Your reference: SSD-10101987

Development Application

Kemps Creek Data Centre (SSD-10101987) 707-769 Mamre Road Kemps Creek NSW 2178, Lots X & Y DP421633 and Lot 22 DP258414

The NSW Rural Fire Service has reviewed the Environmental Impact Statement and provides the following recommendations:

Figure 5: Indicative generator location

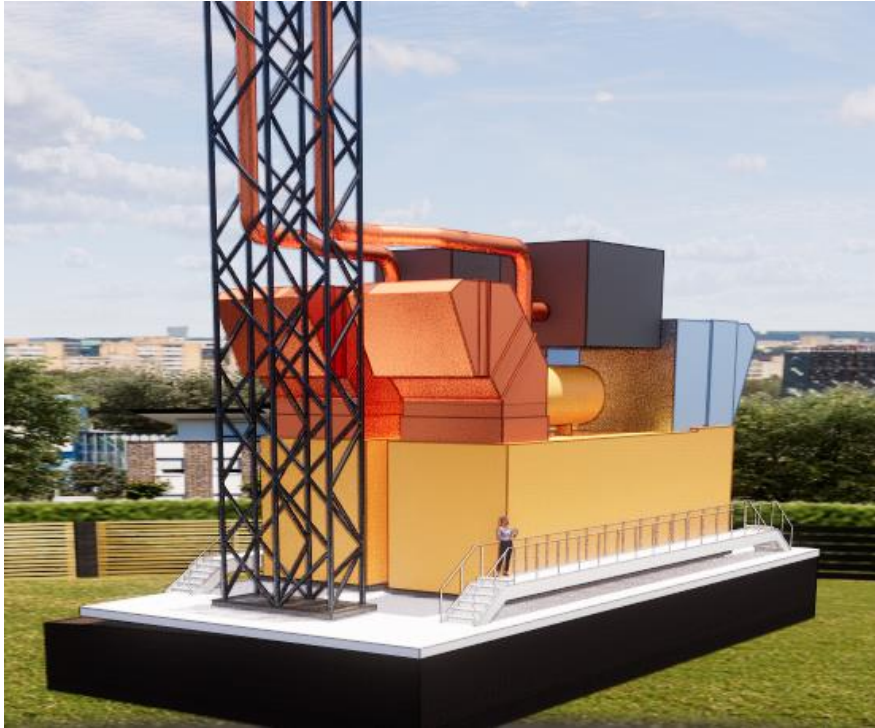
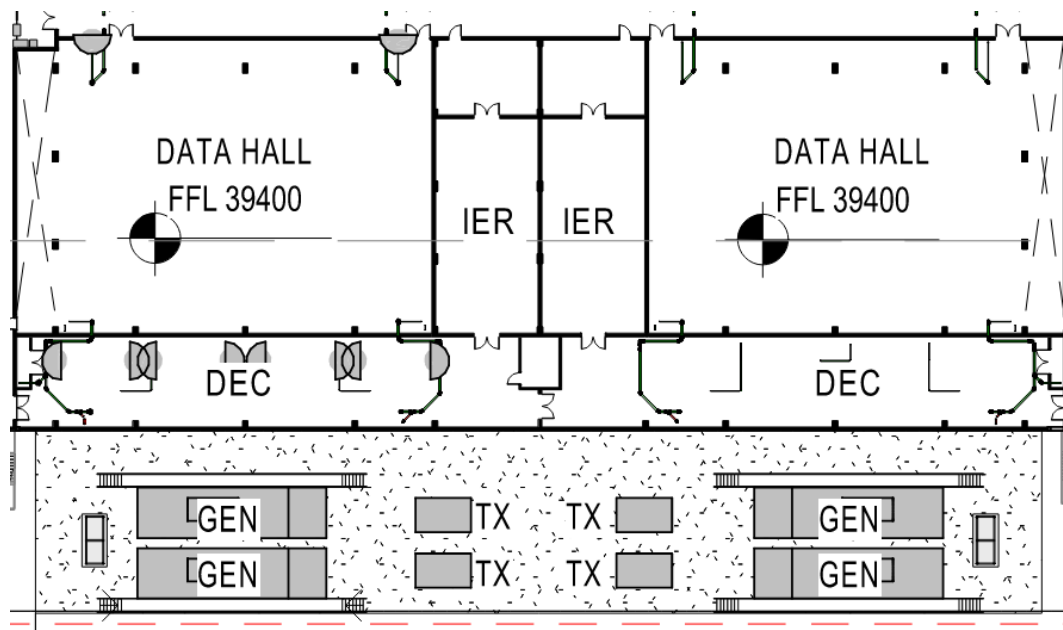
- 6. The proposed diesel storage tanks must be located underground and be designed with a fail-safe system to prevent ignition and propagation from potential bush fire attacks, including the connections to the generators or other exposed parts of the system.

LANDSCAPE CONCEPT PLAN 01

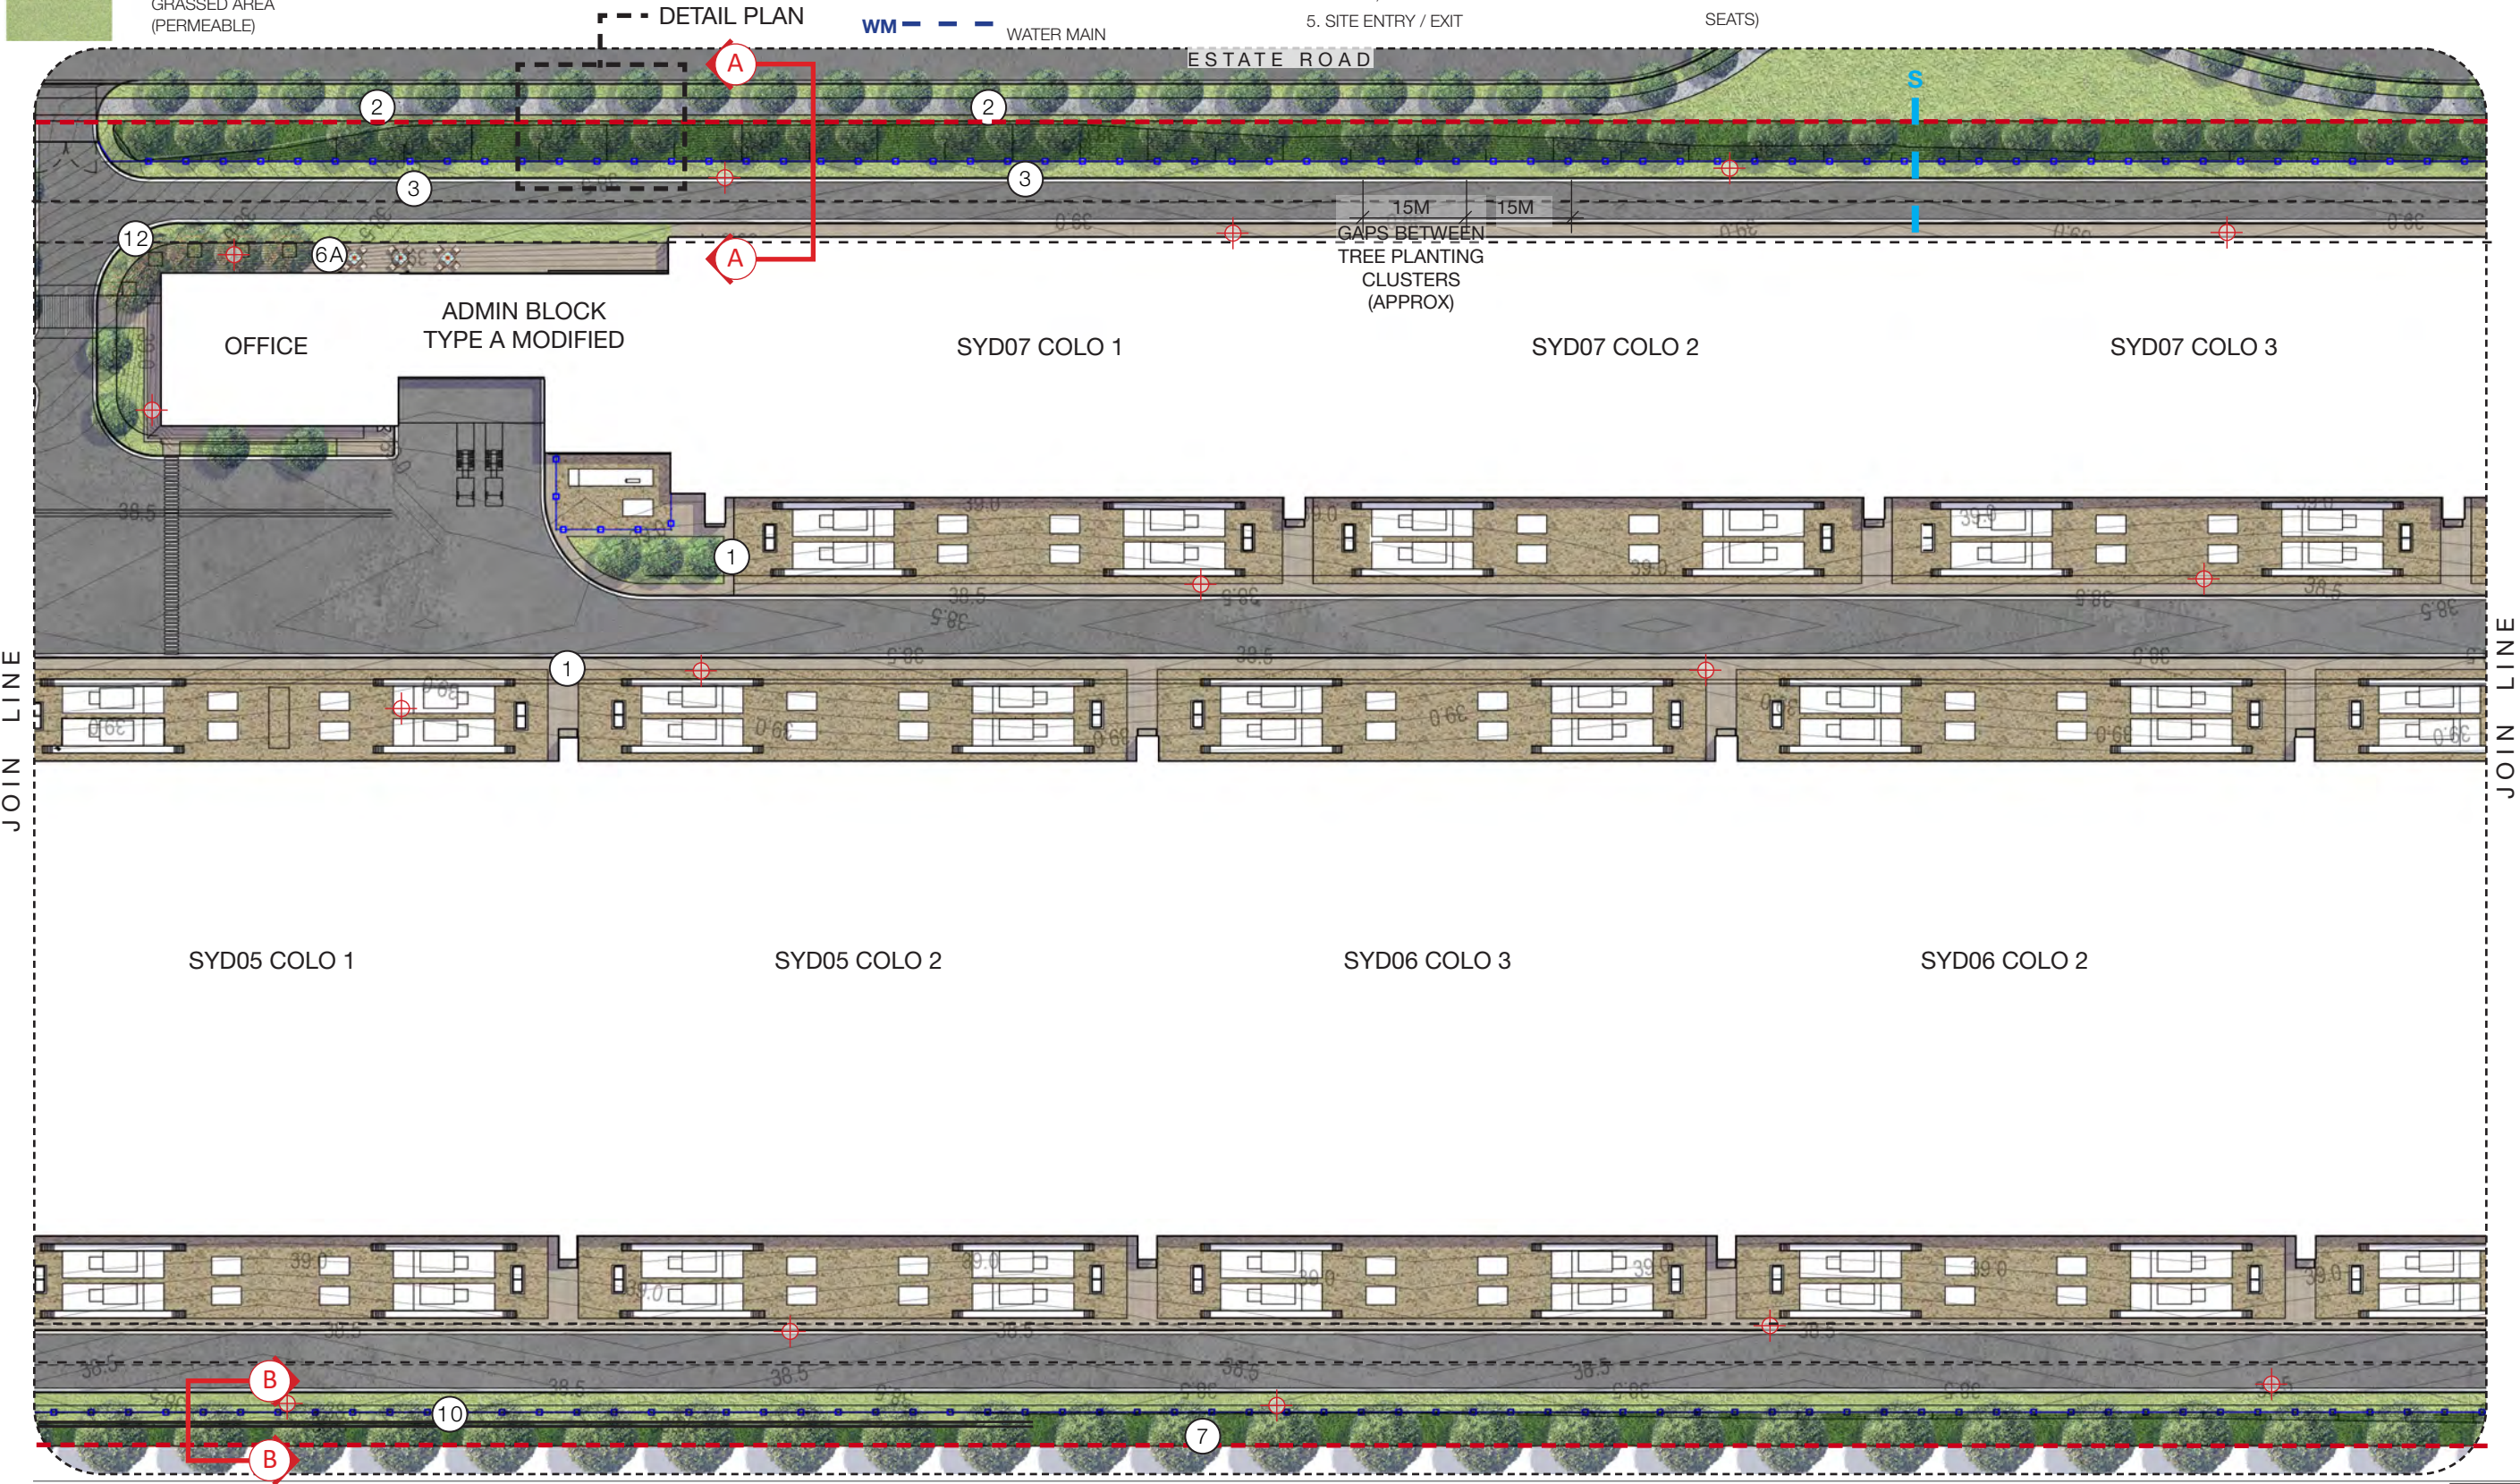
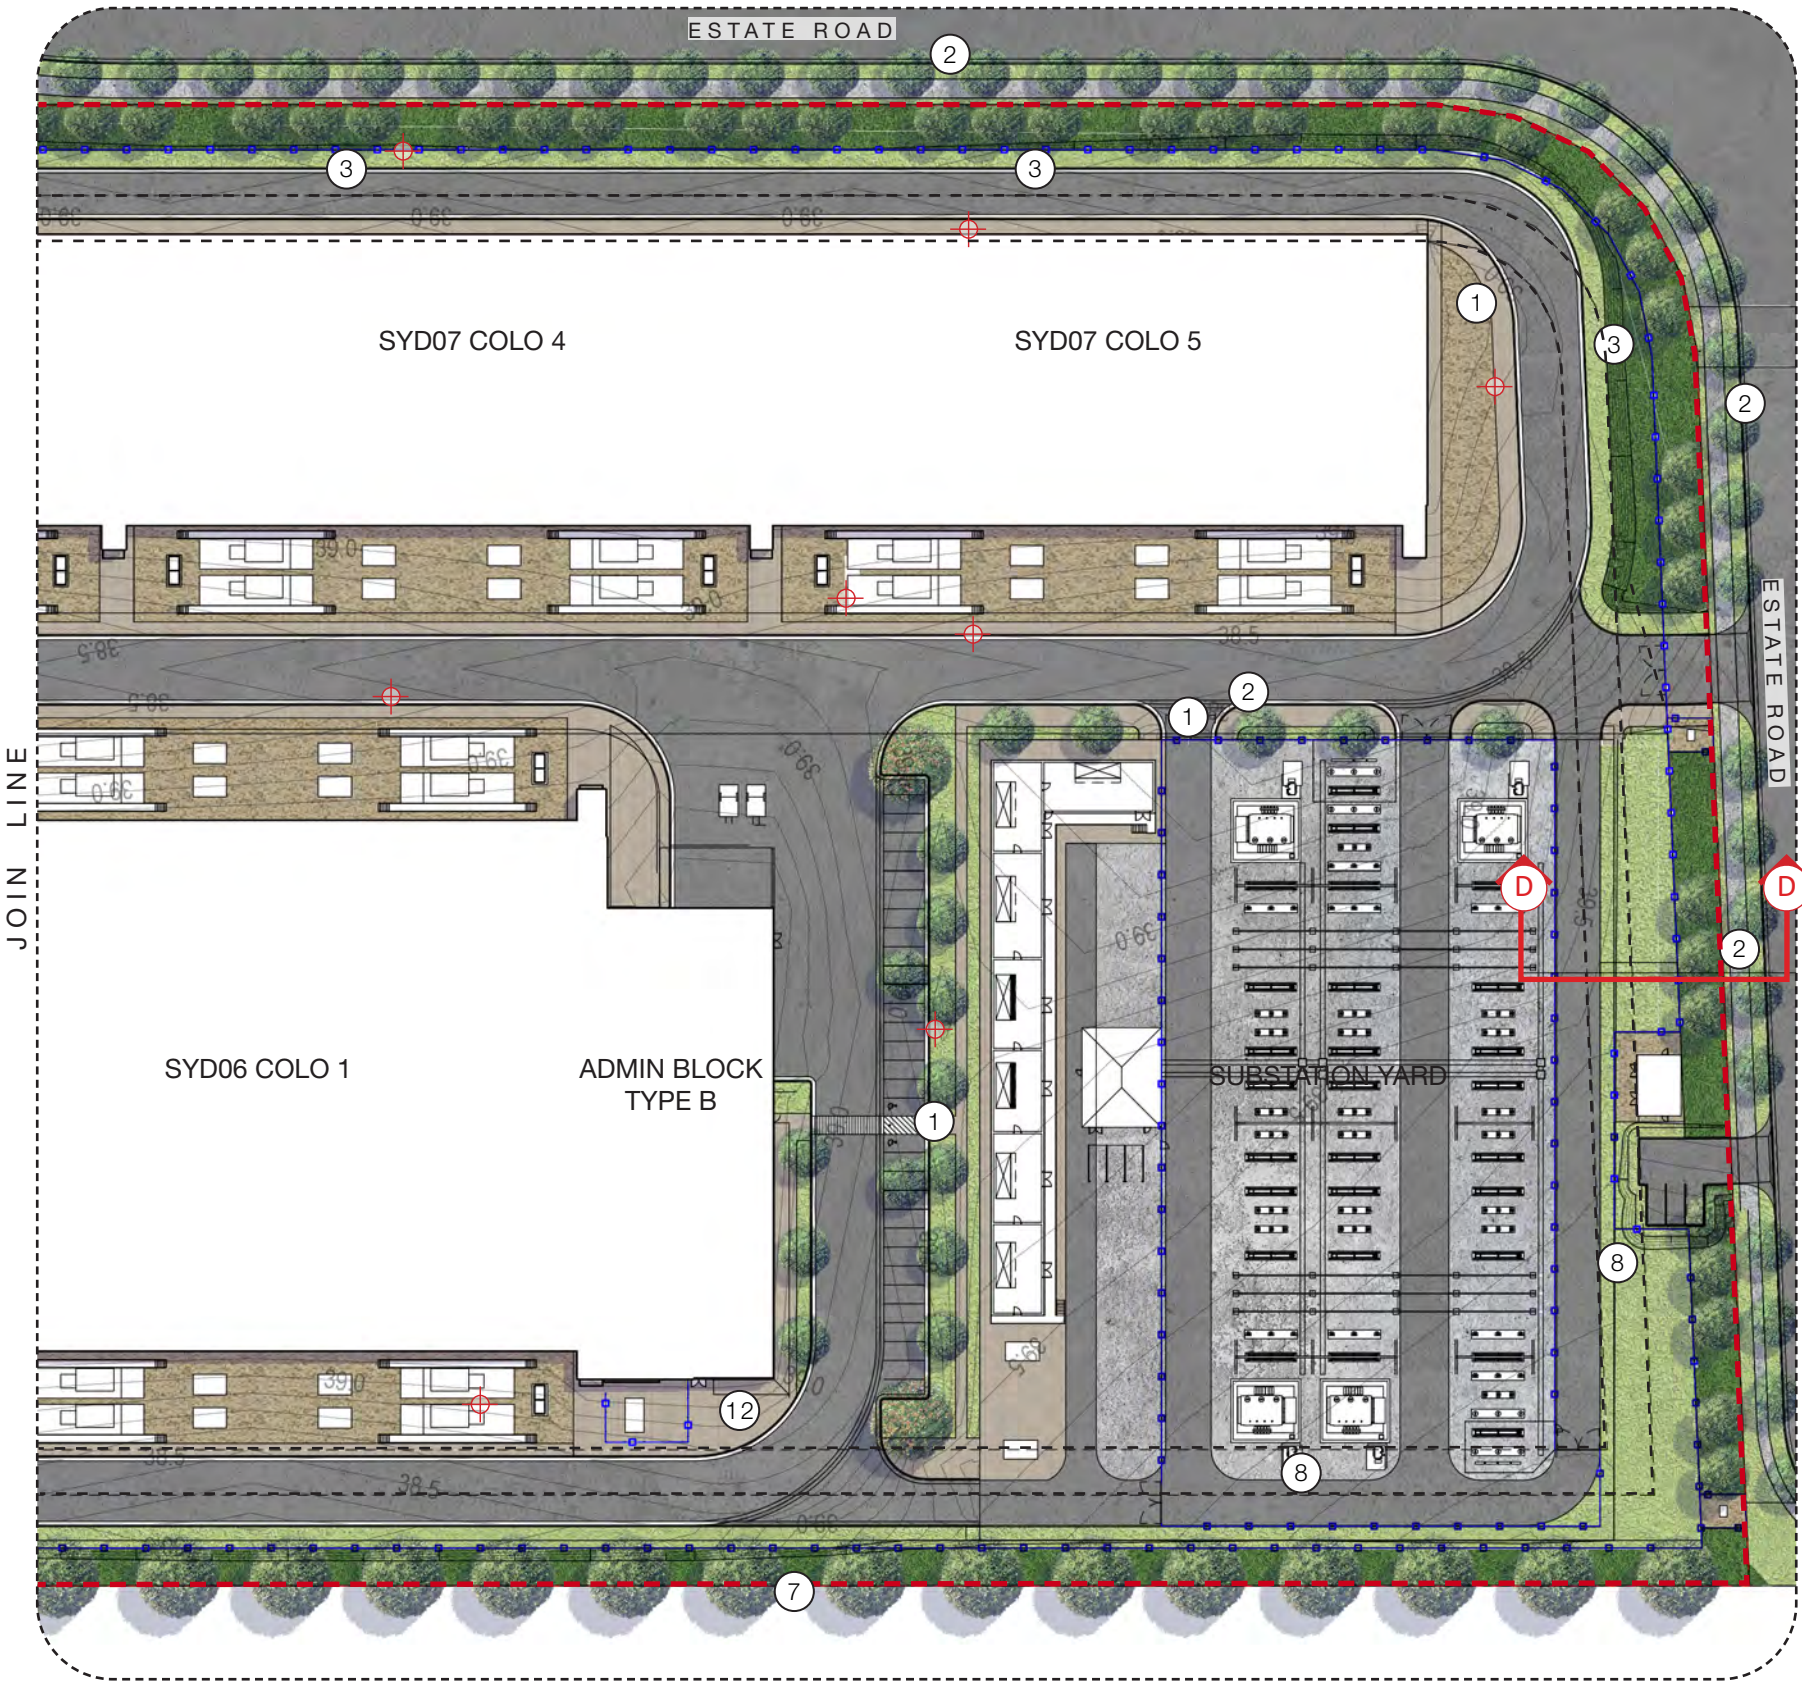
- Leaves and vegetation debris are removed; and
- NSW Rural Fire Service's document Standards for asset protection zones.
- 3. Landscaping within the entire development site of the proposed data centre must comply with Appendix 4 of *Planning for Bush Fire Protection 2019*. In this regard, the following principles are to be incorporated:

- A minimum 1 metre wide area (or to the property boundary where the setbacks are less than 1 metre), suitable for pedestrian traffic, must be provided around the immediate curtilage of the building;

- Planting is limited in the immediate vicinity of the building;
 - Planting does not provide a continuous canopy to the building (i.e. trees or shrubs are isolated or located in small clusters);

- Landscape species are chosen to ensure tree canopy cover is less than 15% (IPA), and less than 30% (OPA) at maturity and trees do no touch or overhang buildings;
